**From:** [sara@krdistrict.org](mailto:sara@krdistrict.org)  
**To:** [Jamey Ayling](#)  
**Cc:** "[kevin eslinger](#)"  
**Subject:** RE: PD-24-00002 Parke Creek Landing - Notice of Application  
**Date:** Monday, February 10, 2025 10:47:02 AM

The Parke Creek Landing Planned Unit Development lies within the KRD service area, and a portion of the land does have KRD water rights assigned to them. See below for comments on the Parke Creek Landing Planned Unit Development.

**Subject:** PD-24-00002 Parke Creek Landing - Notice of Application

SITE DEVELOPMENT PLAN - PARKE CREEK LANDING  
A PORTION OF THE NW 1/4 & A PORTION OF THE SW 1/4 OF SECTION 34, T. 18 N., R. 20 E., W.M.  
KITITAS COUNTY, STATE OF WASHINGTON

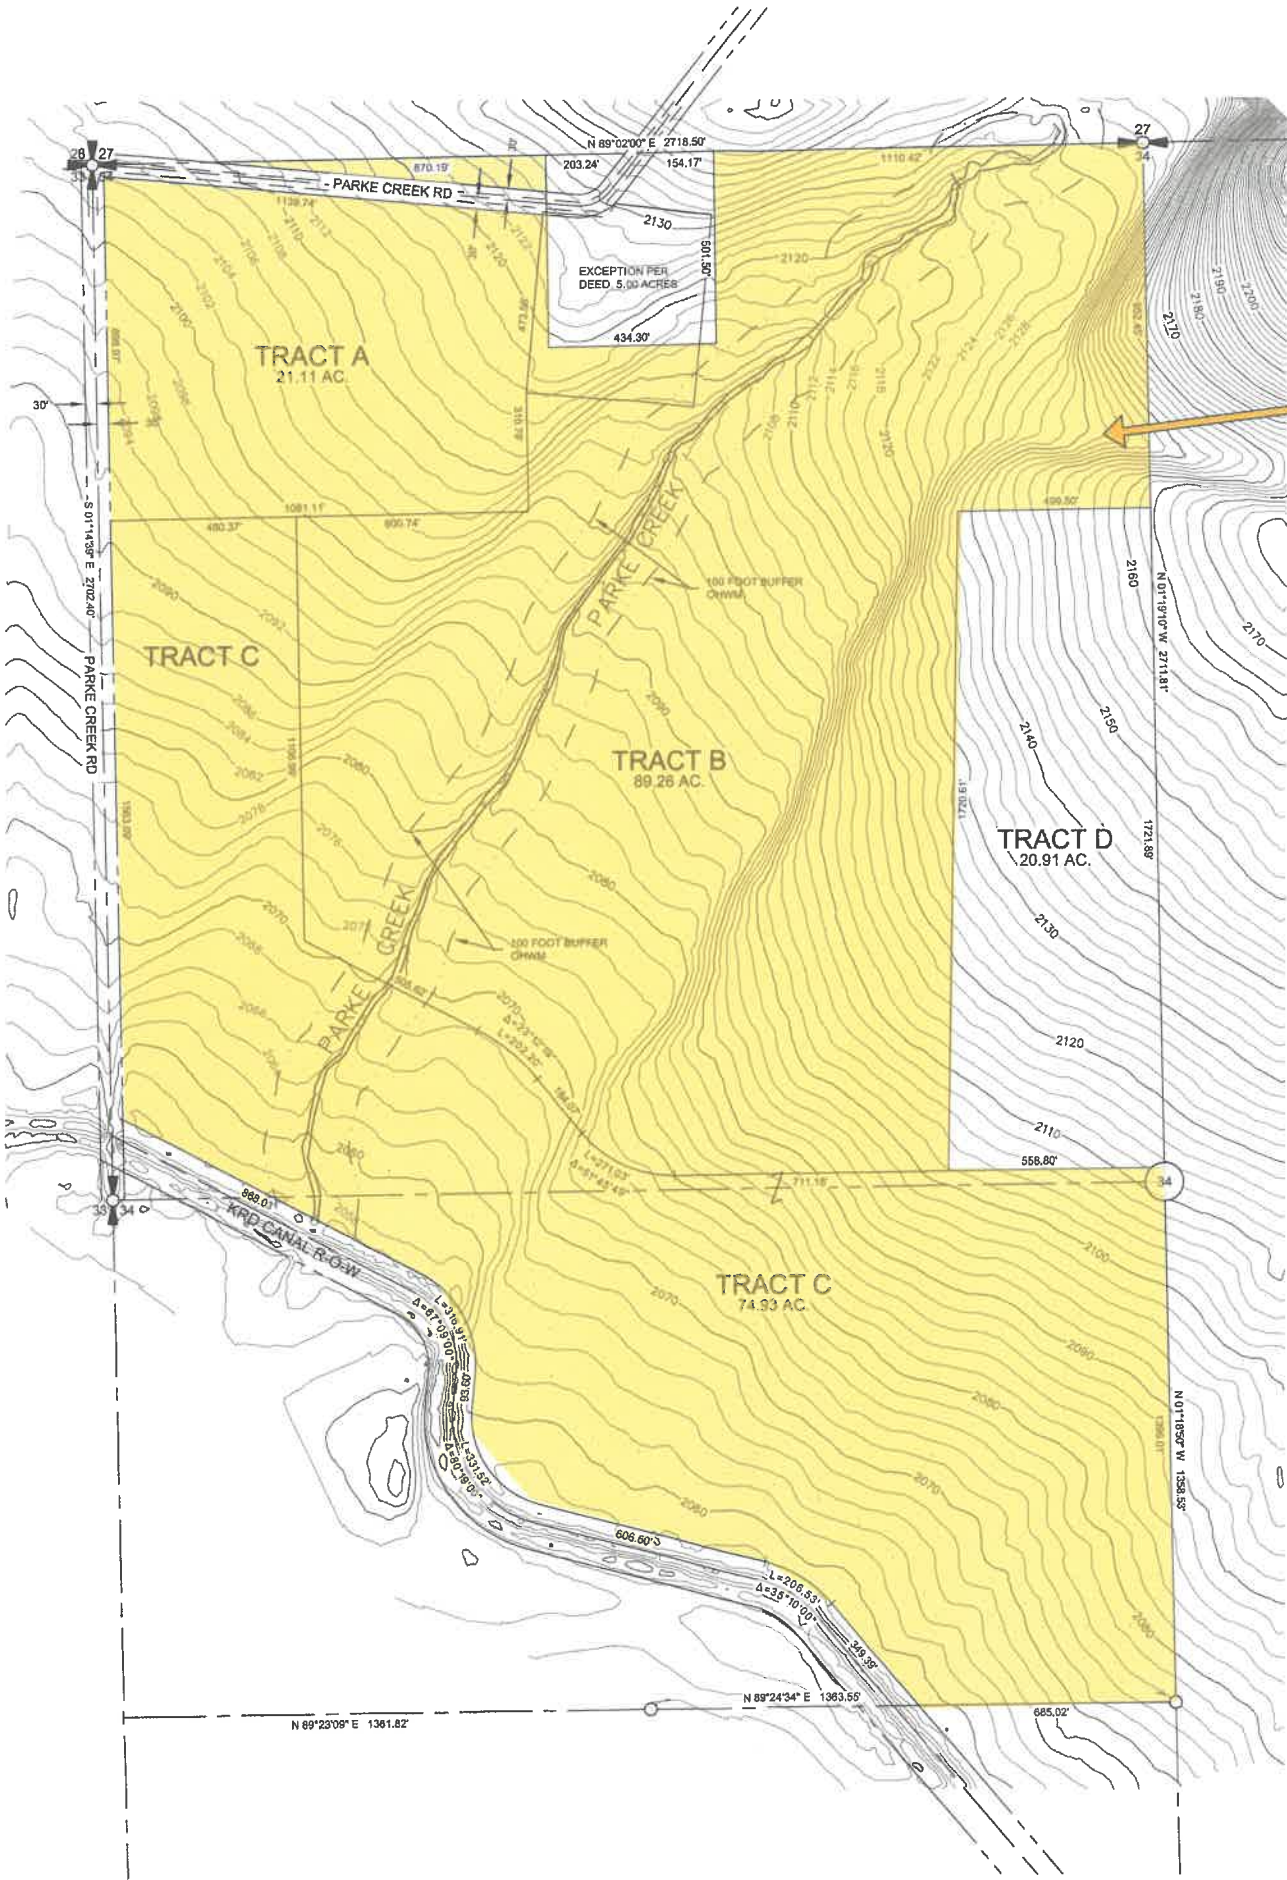
1. Park Creek Landing will need to follow KRD's division guidelines.
2. The landowner will need to work with KRD and potentially move existing water rights as they lie on the parcel so that irrigation water can be applied to the residential lots. As it is designed and described in the Project Narrative, most of the residential lots are not eligible to receive KRD water. Prior to final approval the landowners will need to complete a Water Distribution Plan for all KRD irrigation water, to be recorded with the Kittitas County Auditor's Office upon final approval.

3. Modification of any existing or the addition of a new pump station on the KRD's North Branch Canal will require KRD's approval prior to work beginning.
